October 31, 2014

**Subject: Convenience Store and Fuel Station Development
2282 Congress Street
Amended Site Plan Application
Response to Tom Errico's Review Comments Dated September 17, 2014**

PORTLAND, MAINE CUMBERLAND COUNTY OFFSITE IMPROVEMENTS PROJECT

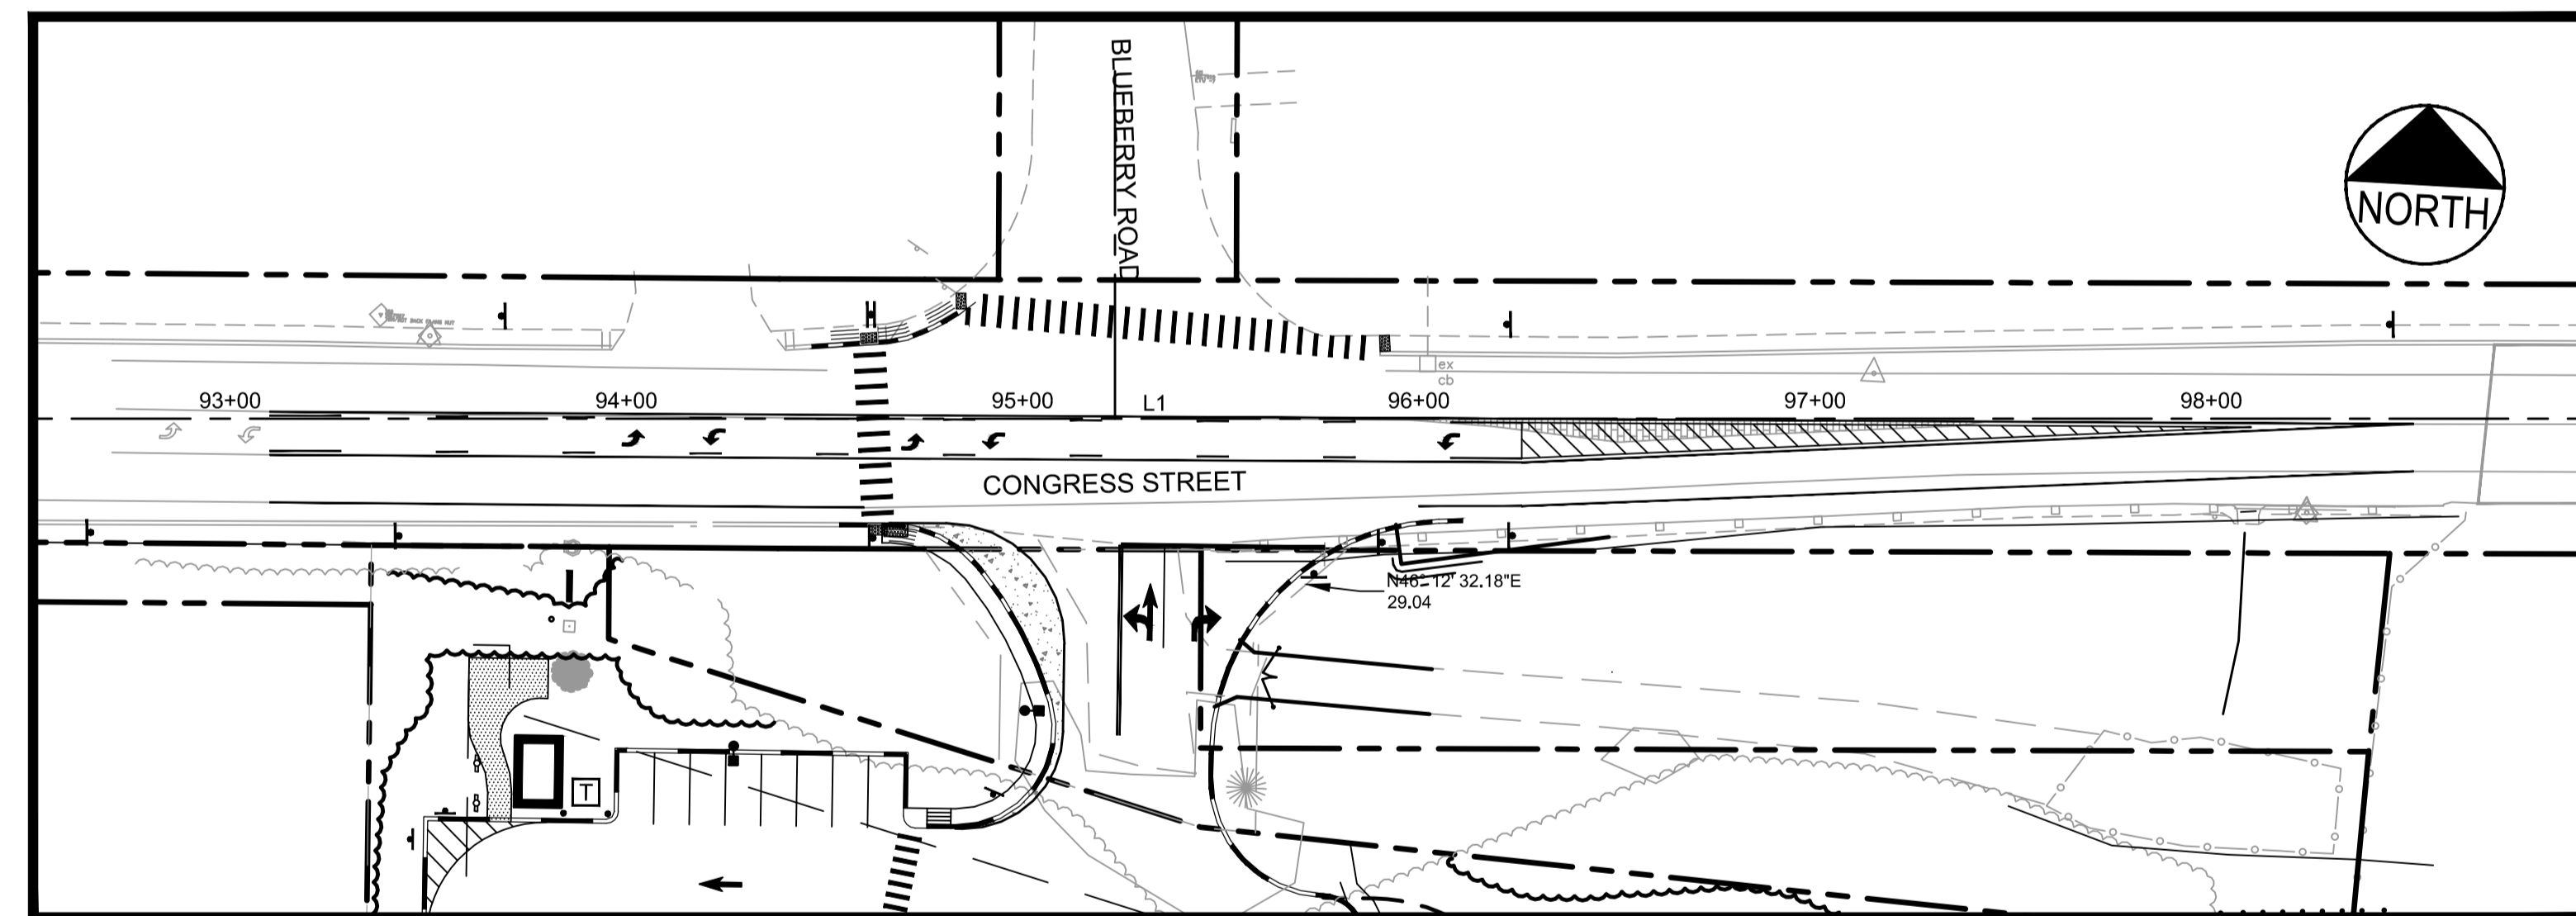
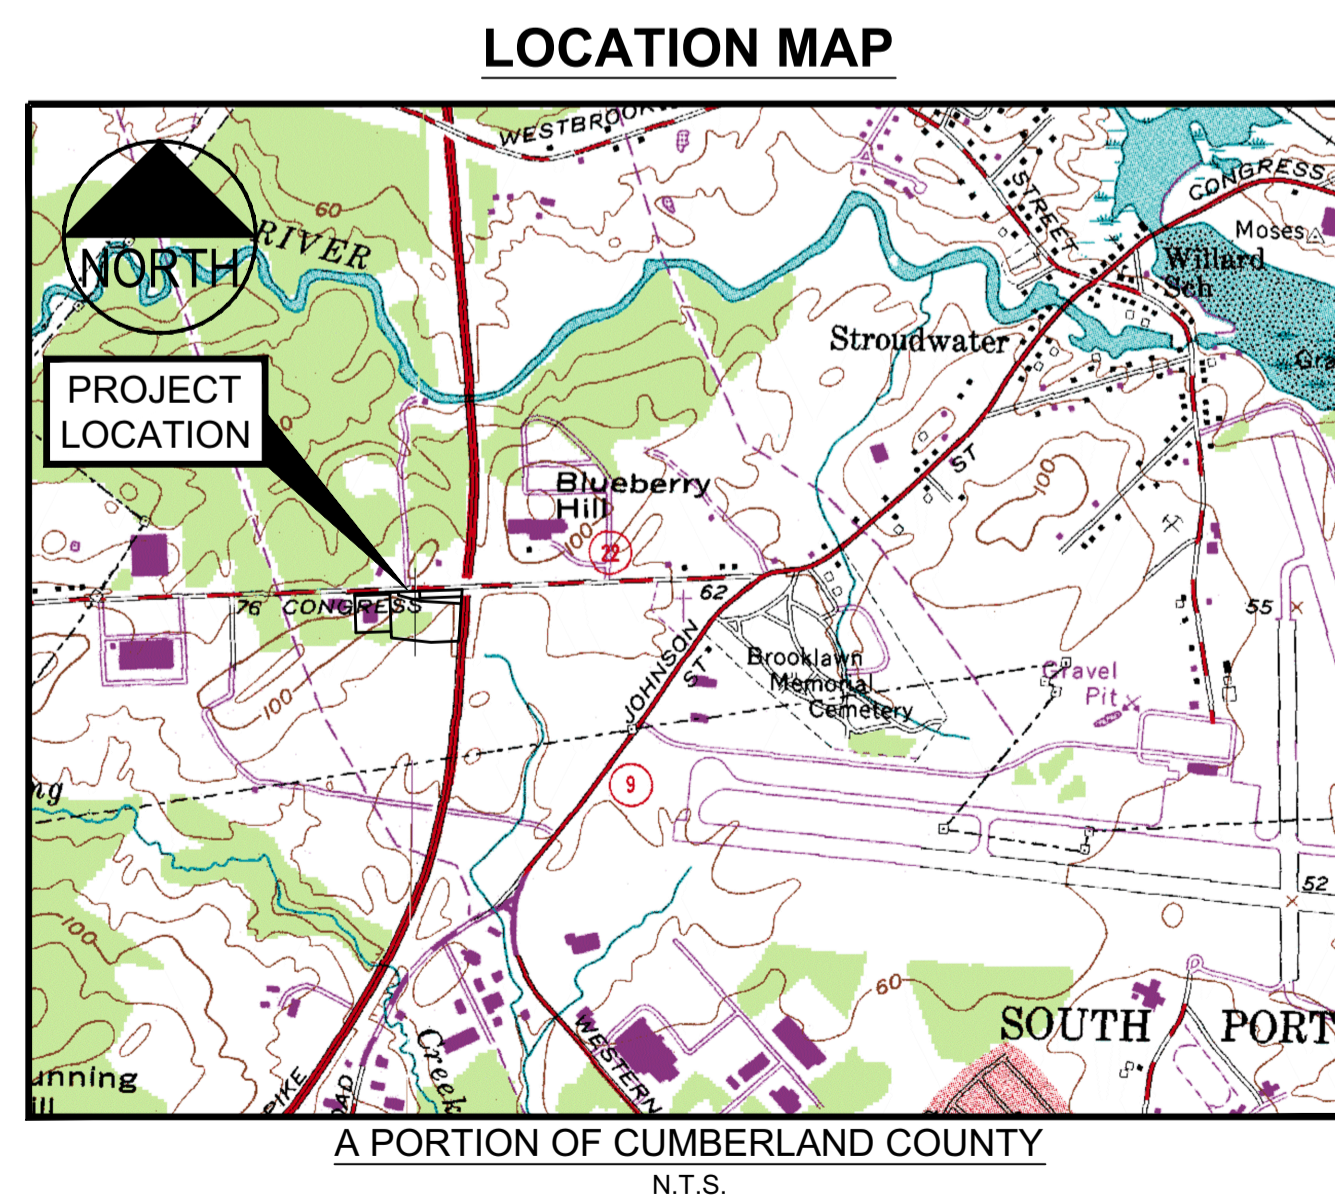
A detectible warning panel shall be installed on the easterly corner of Blueberry Road.

Right-of-way boundaries on the north side of Congress Street should be provided and it should be confirmed that all activity will occur in the public right-of-way.

A detectible warning strip has been added to the plans and reflected on the enclosed Sheet C-4.0 OFF General Improvements Plan and Profile.

The ROW for the north side of Congress Street has been digitized from a plan titled “Maine Turnpike Authority, Maine Turnpike Property and Right-of-way Plan Section 1-Kittery to Portland” by HNTB Dated February 1997. The offsite plans have been revised to include this line.

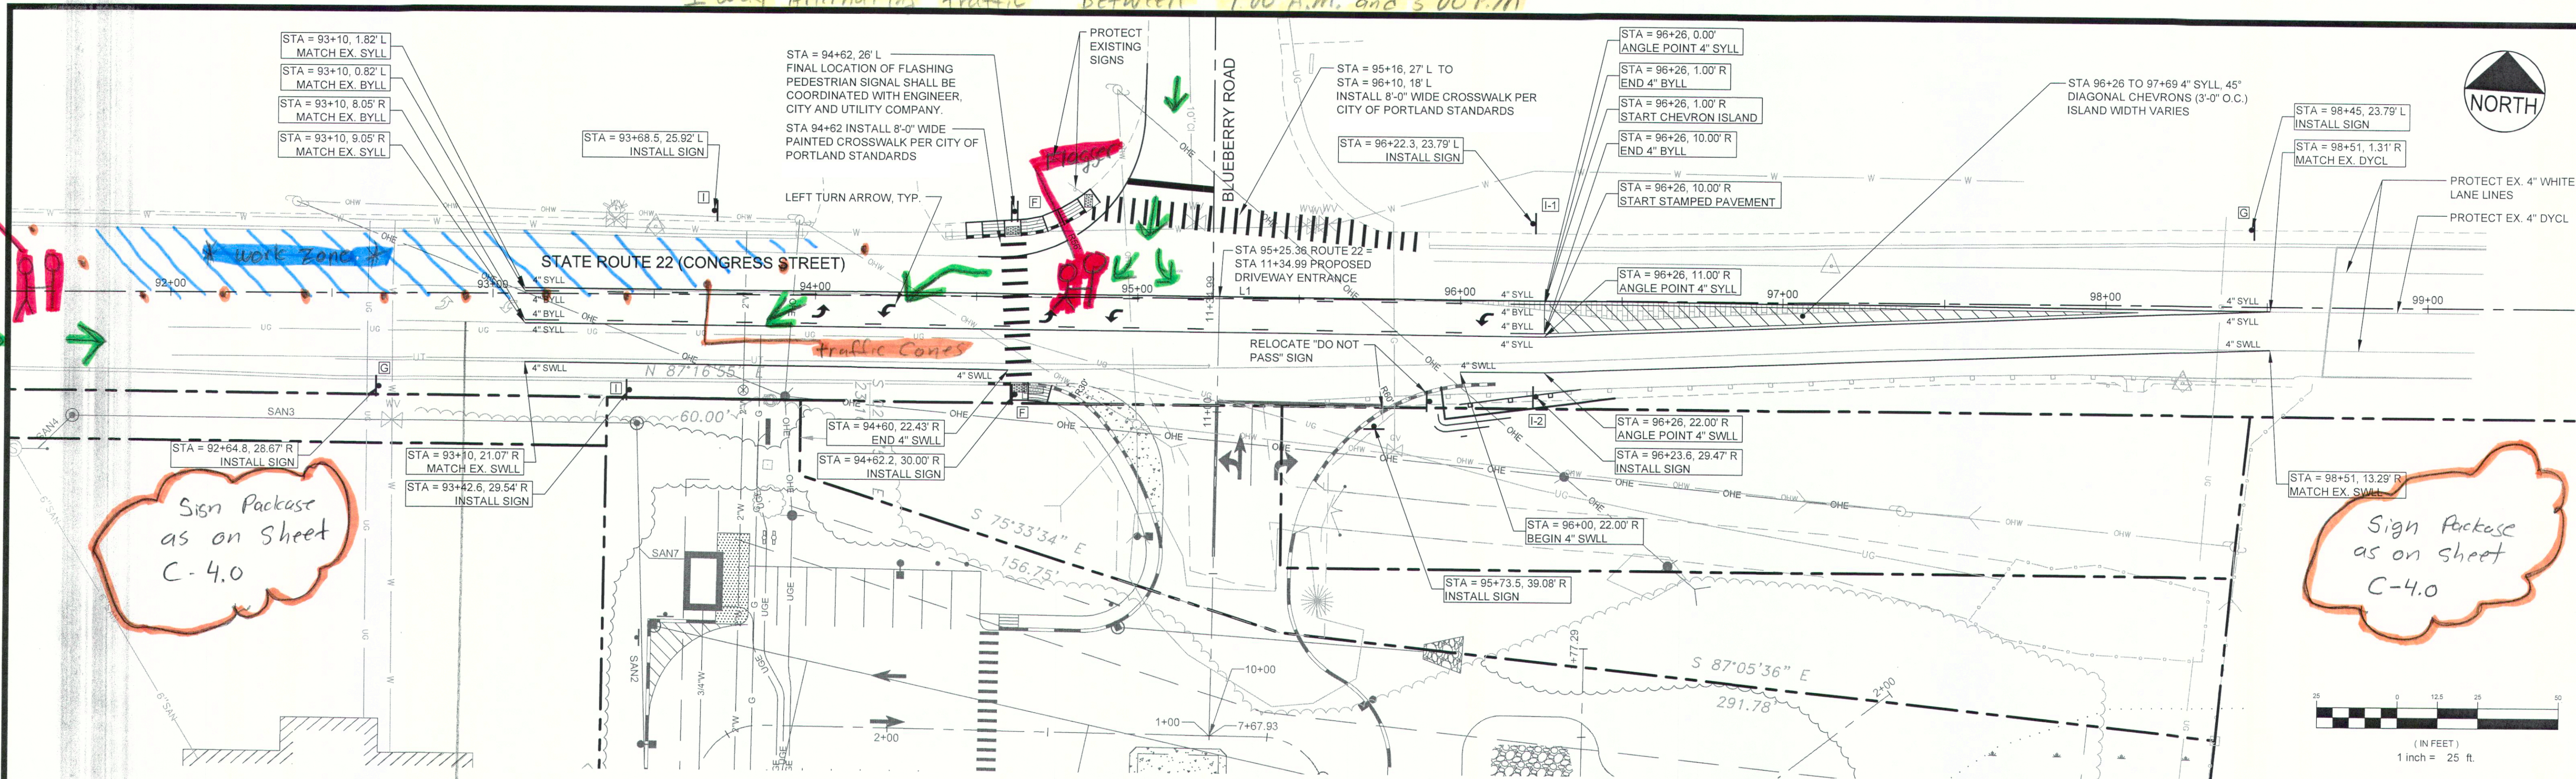
I find the construction plan to be acceptable with the requirement that a variable message board (s) be provided that notes use of Skyway Drive as an alternative route during construction.

The updated construction plan includes signage requirements including variable message boards and enclosed with this letter.
